MORGAN AND MORECAMBE OFFSHORE WIND FARMS: TRANSMISSION ASSETS

Works Plans - Onshore and Offshore – Part 1 of 2

December 2024
Rev: F02

PINS Reference: EN020028
APFP Regulations: 5(2)(j)
Document reference: B7/F02

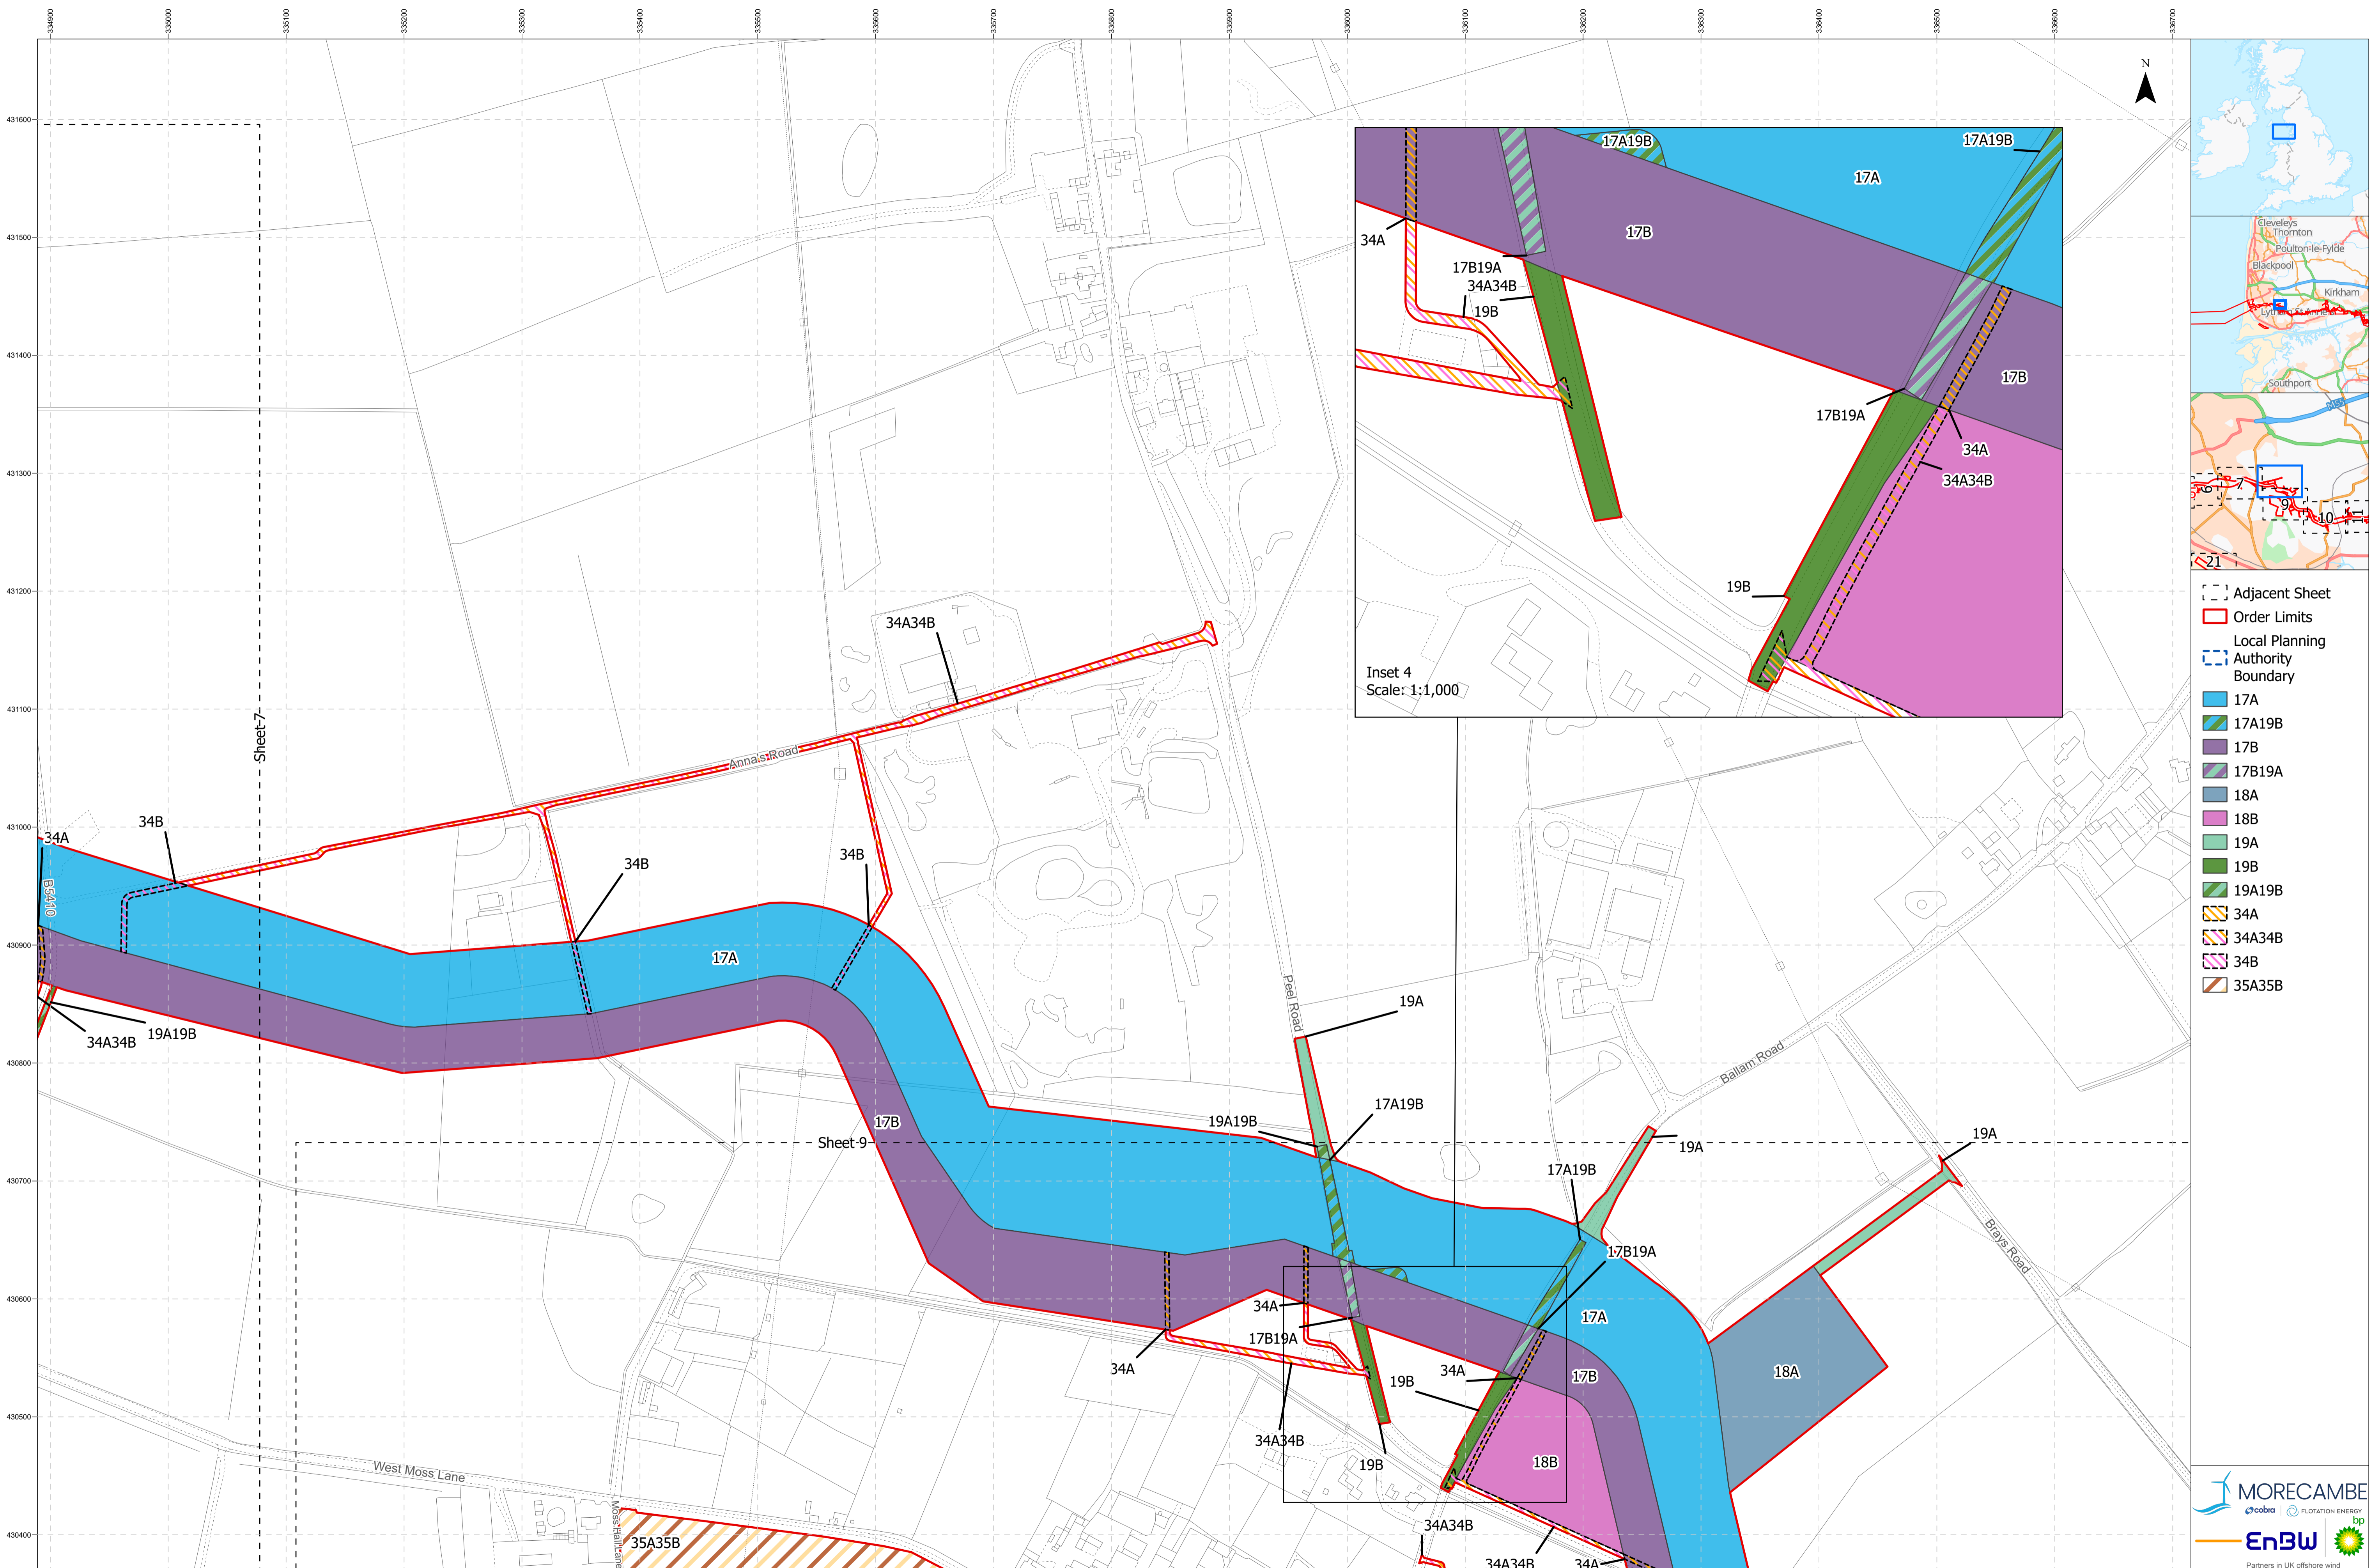
Sheet Number	Change requested by	Change Made	Reason for Change	Revision	Submission deadline
7	The Applicants	Permanent access (Work No. 34A) has been extended, near to Moss Sluice watercourse.	A review of the works plans identified that permanent access (Work No. 34A) to Morgan's onshore export cable corridor (Work No. 17A) was previously omitted. This has now been updated to reflect the Morgan permanent access (Work No. 34A) to cable corridor (Work No. 17A)	F02	S51 advice update
7	The Applicants	The permanent access (Work No. 34A34B) to both Morecambe and Morgan's onshore cable works (Work No. 17A and 17B) has been refined west of Midgeland Road.	A review of the works plans identified that permanent access (Work No. 34A) did not need to extend over Morgan's onshore export cable corridor (Work No. 17A). Similarly, permanent access (Work No. 34B) did not need to extend over Morecambe's onshore export cable corridor (Work No. 17B).	F02	S51 advice update
